KIRKLEES METROPOLITAN COUNCIL INVESTMENT & REGENERATION SERVICE

DELEGATED DECISION TO DETERMINE PLANNING APPLICATIONS

Reference No:	2024/62/91594/W
Site Address:	1, Dryclough Avenue, Crosland Moor, Huddersfield, HD4 5JU
Description:	Erection of single storey side and rear extensions
Recommending Officer:	Laura Yeadon

DECISION – REFUSED

Proposed Plans and Elevations

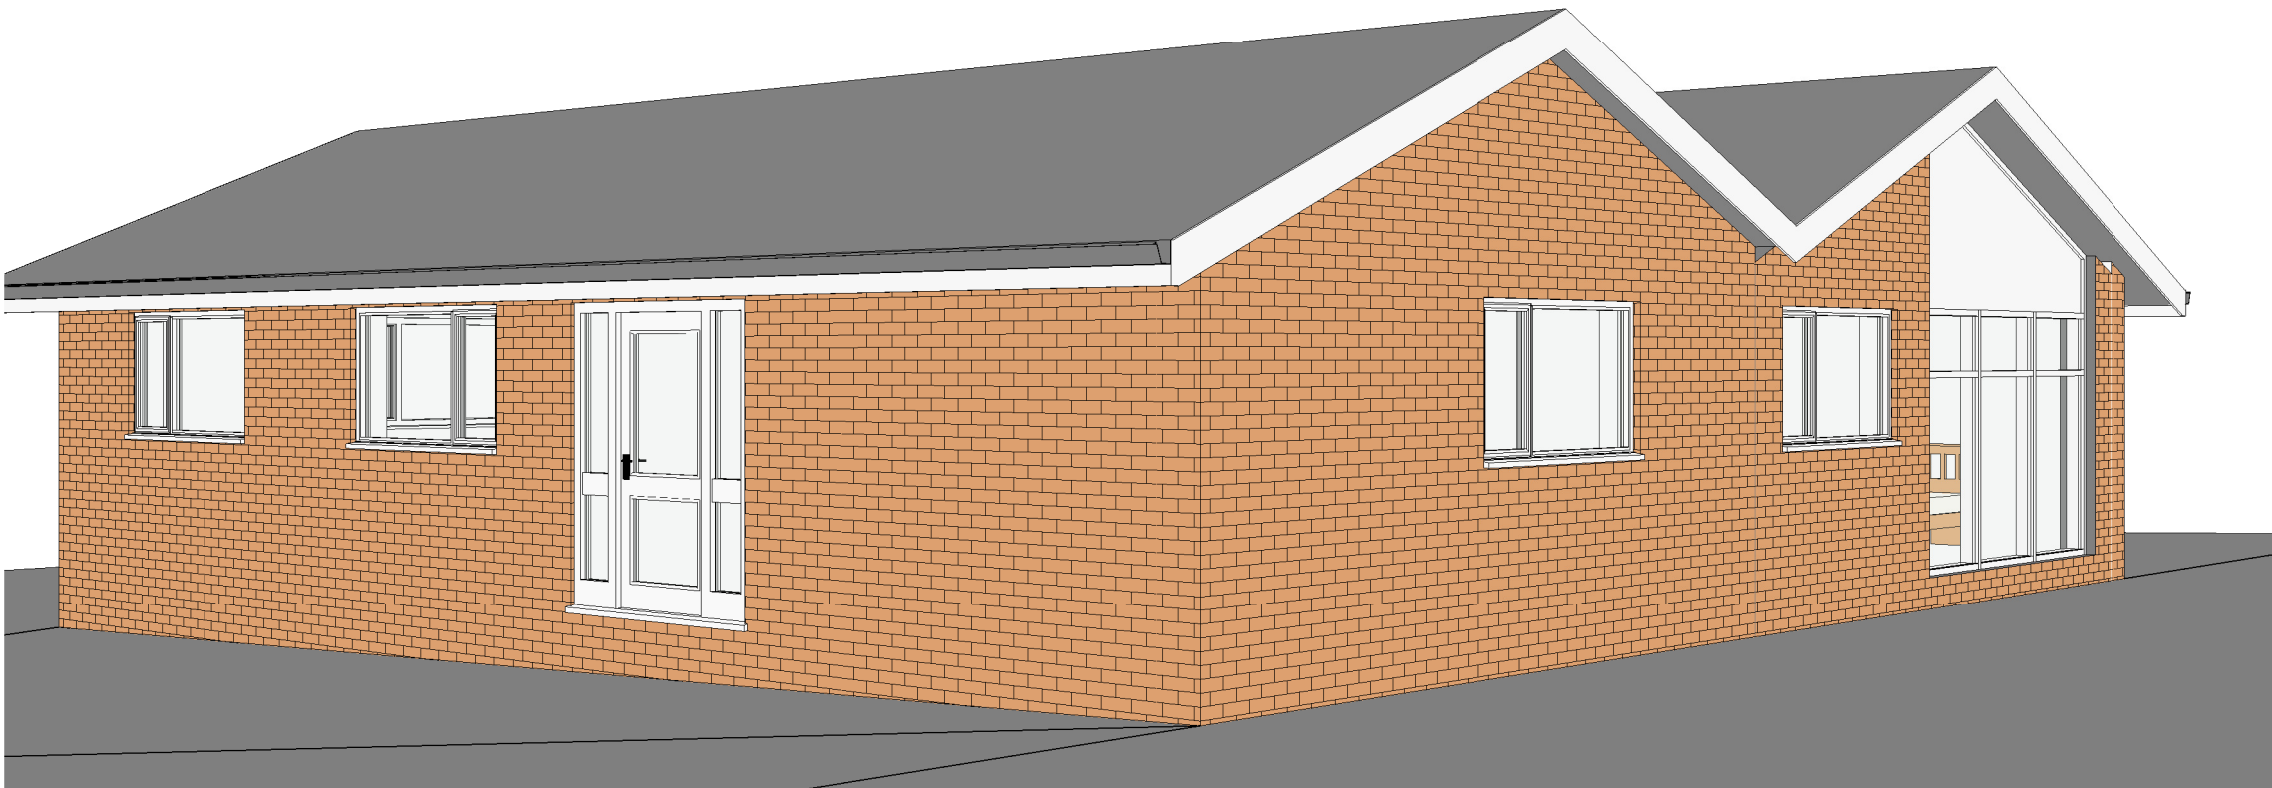
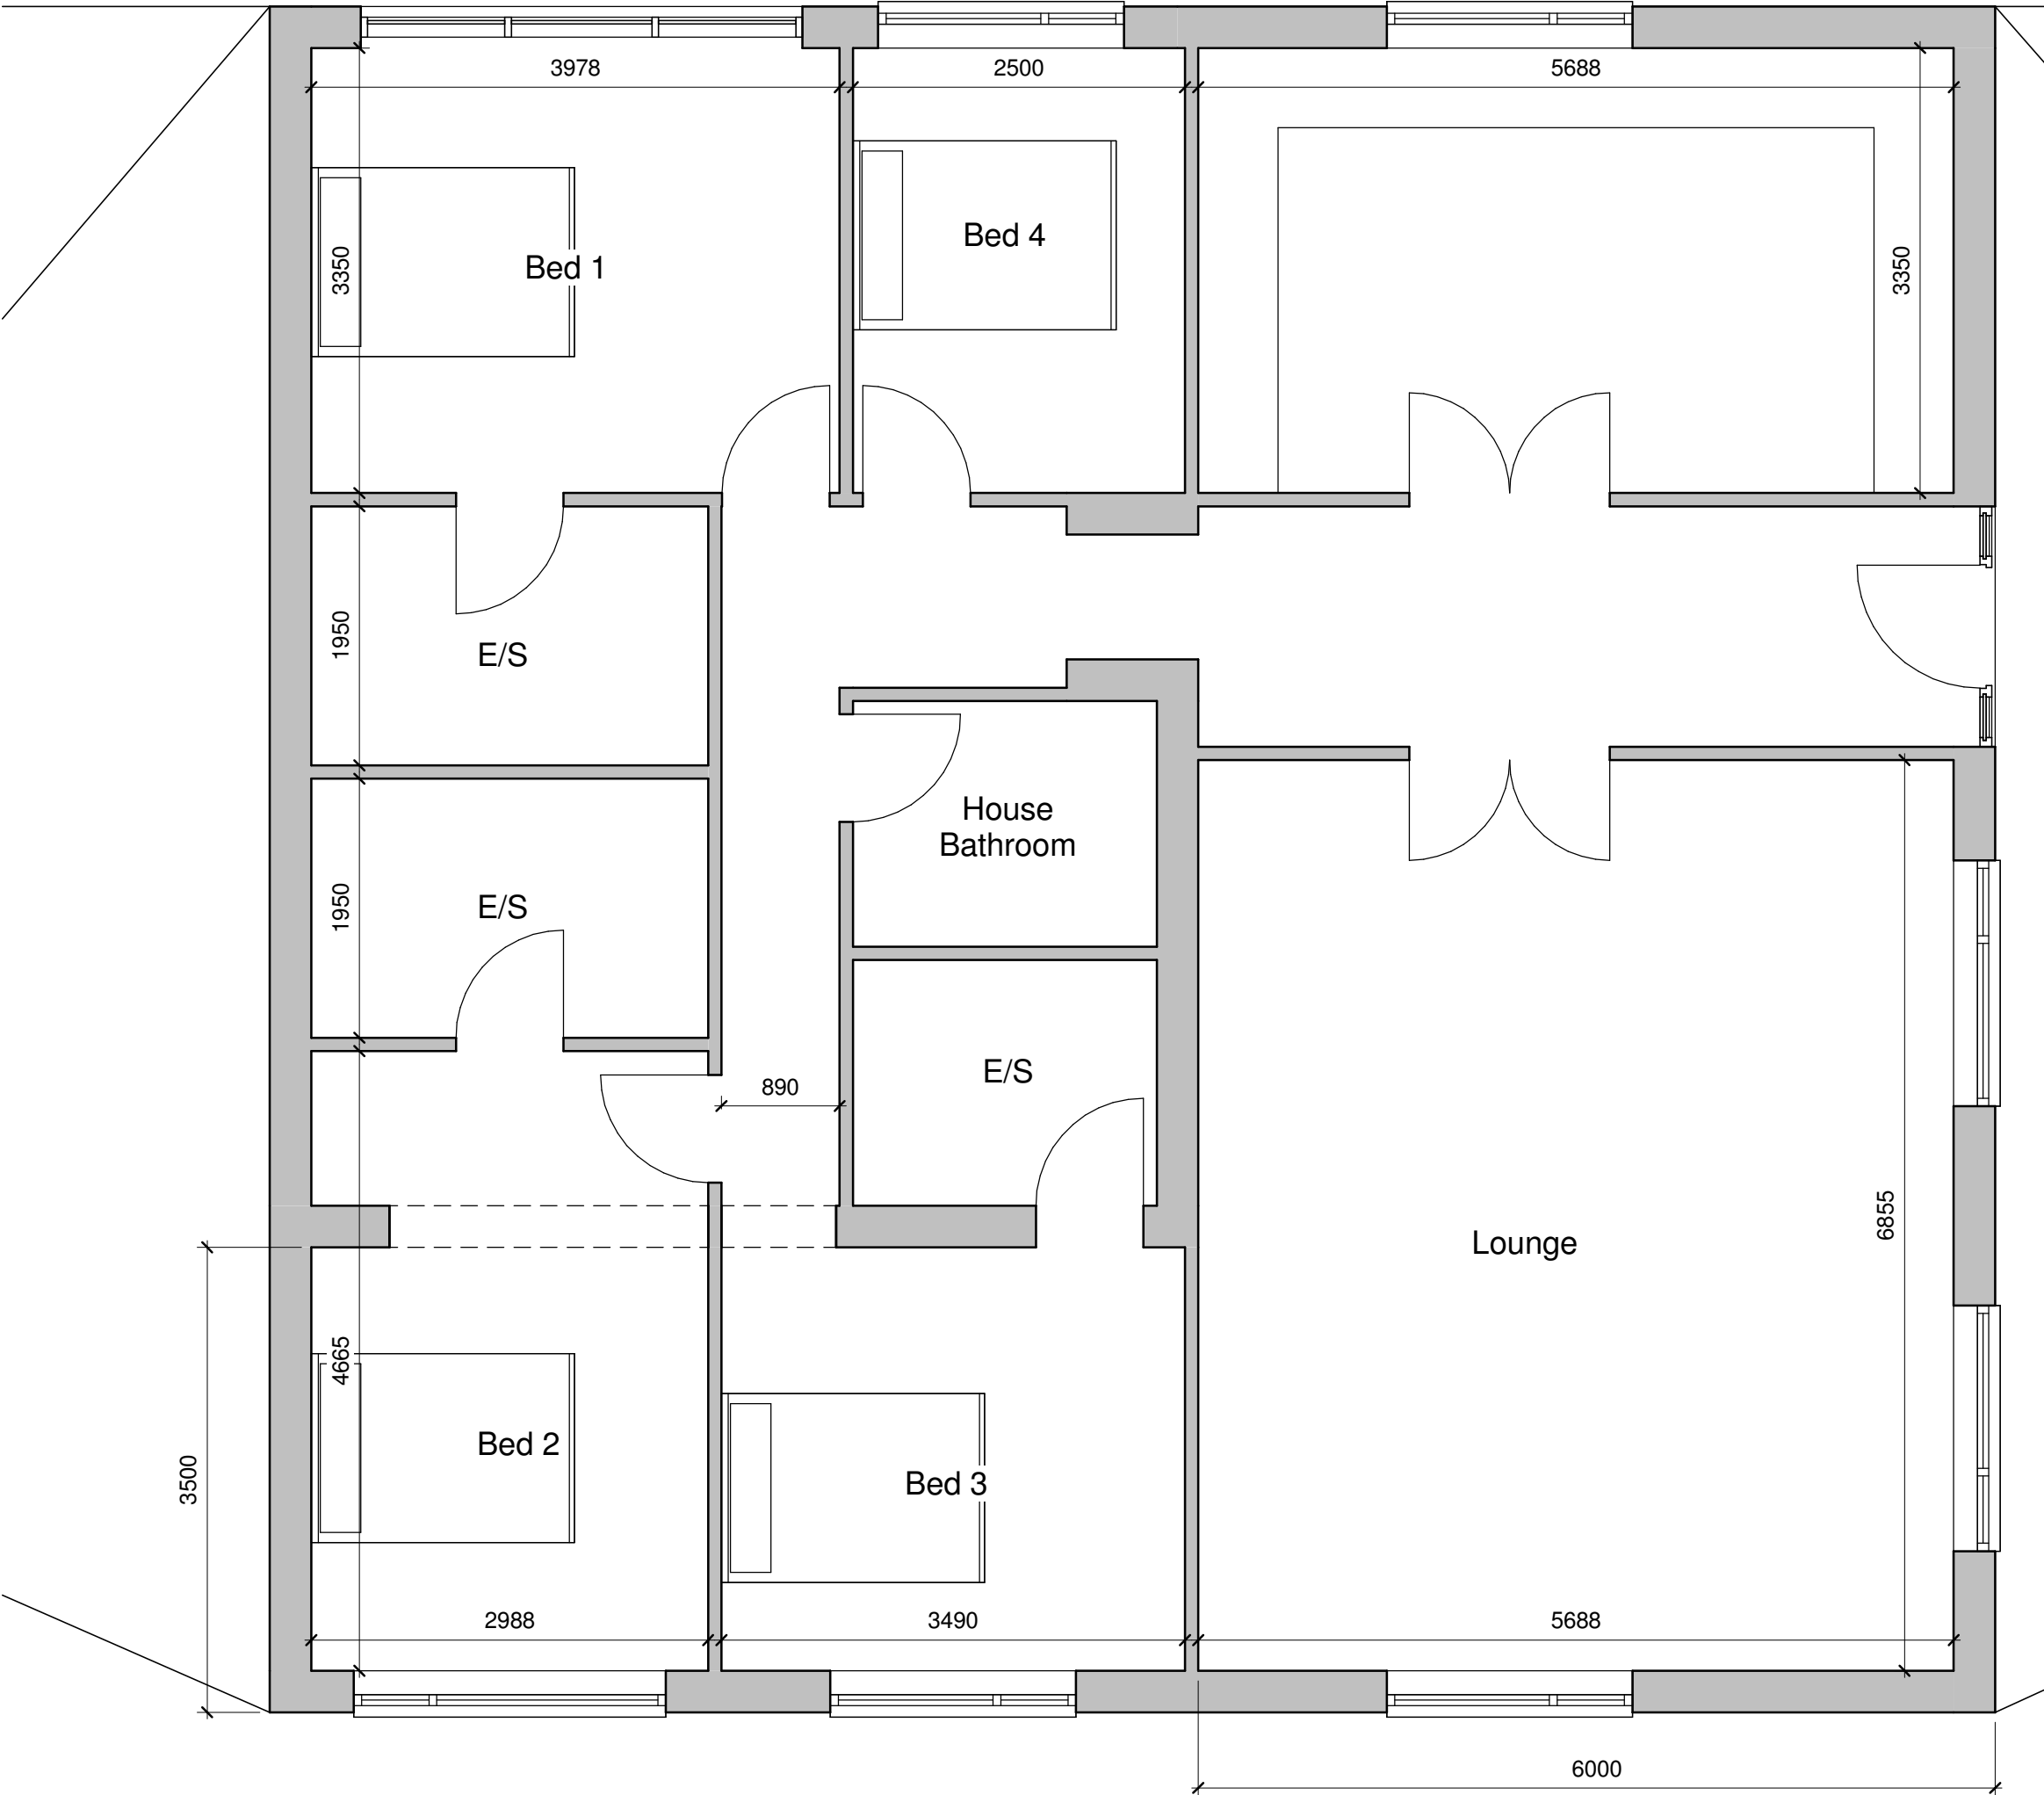
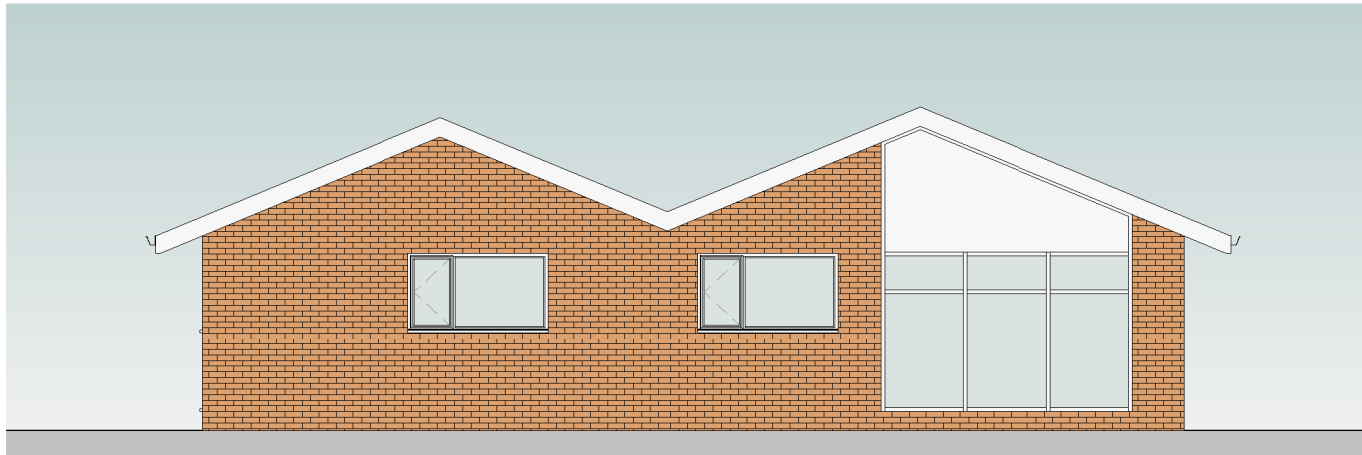
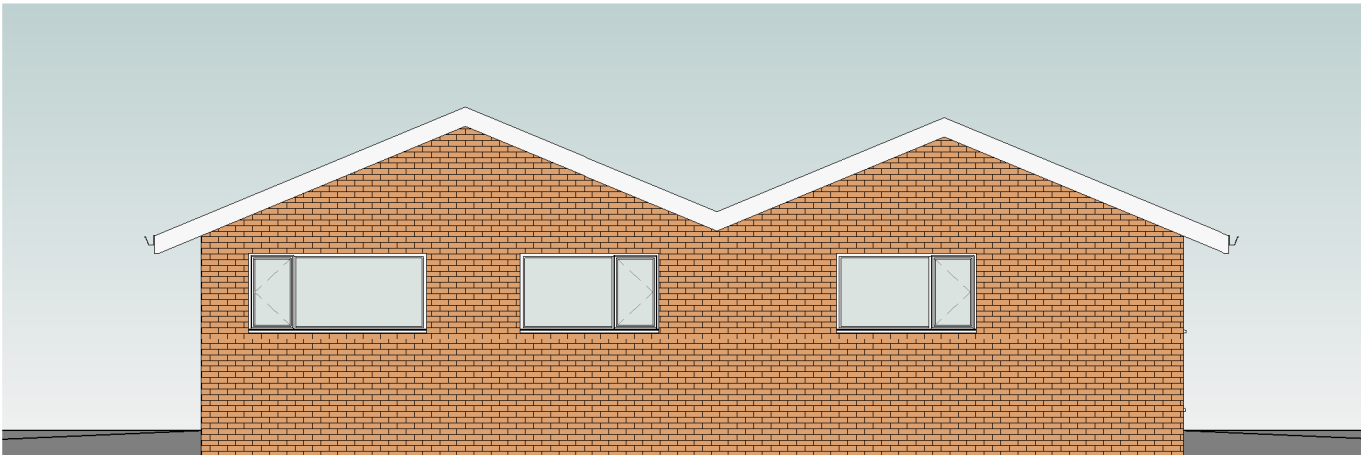
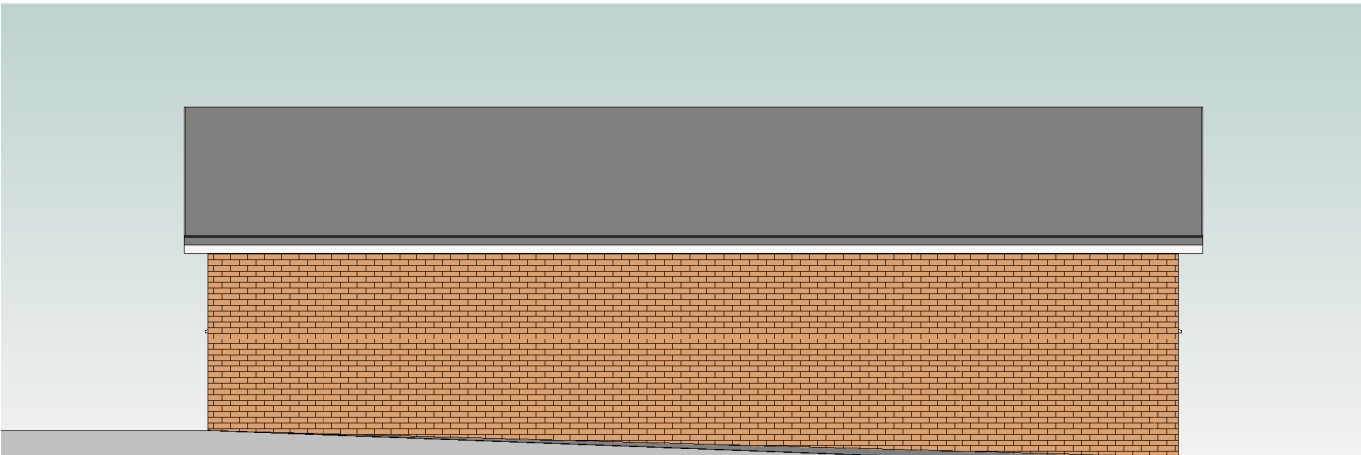
In this instance, turning to the proposed side extension, this would enlarge the property to the north, with a roof line that would be marginally set down from the roof of the existing dwelling by approximately 0.2 metres. The roof line would be pitched with a gabled front and rear elevation to replicate the existing dwelling.

However, with regard to the specifics in relation to side extension under sub-section 5.17 of the SPD, the extension would have a width of 6 metres along the full depth of the north elevation which is more than two thirds of the width of the house (which is 7 metres in width). The extension would lie flush with the front elevation and is not set back. As such, the proposed works would not comply with the with current adopted guidance. No information has been submitted to 'justify' the overall size of the works.

In terms of the single storey rear elevation and its compliance with the SPD, this would not project more than 4 metres from the rear elevation of the property and is not within 1 metre of a boundary. As this would project beyond to the rear of both the original house and proposed extension, this part of the proposal is not considered to be subservient and is therefore also contrary to the SPD.

Due to the overall design and style of extensions proposed, the design of the extension, whilst visually appearing as replication of the existing house would result in a design which gives the appearance of an additional attached property which would be out of character with the street scene which is characterised by detached dwellings. In terms of the impact on the host dwelling, such a large structure in such a prominent position on a bend within the cul-de-sac neither respects or compliments the character of the host dwelling. The works, when viewed cumulatively with the rear extension would result in a contrived appearance which would almost double the width of the original dwelling and would not constitute subservient design, contrary to the Key Design Principle 2 of the SPD.
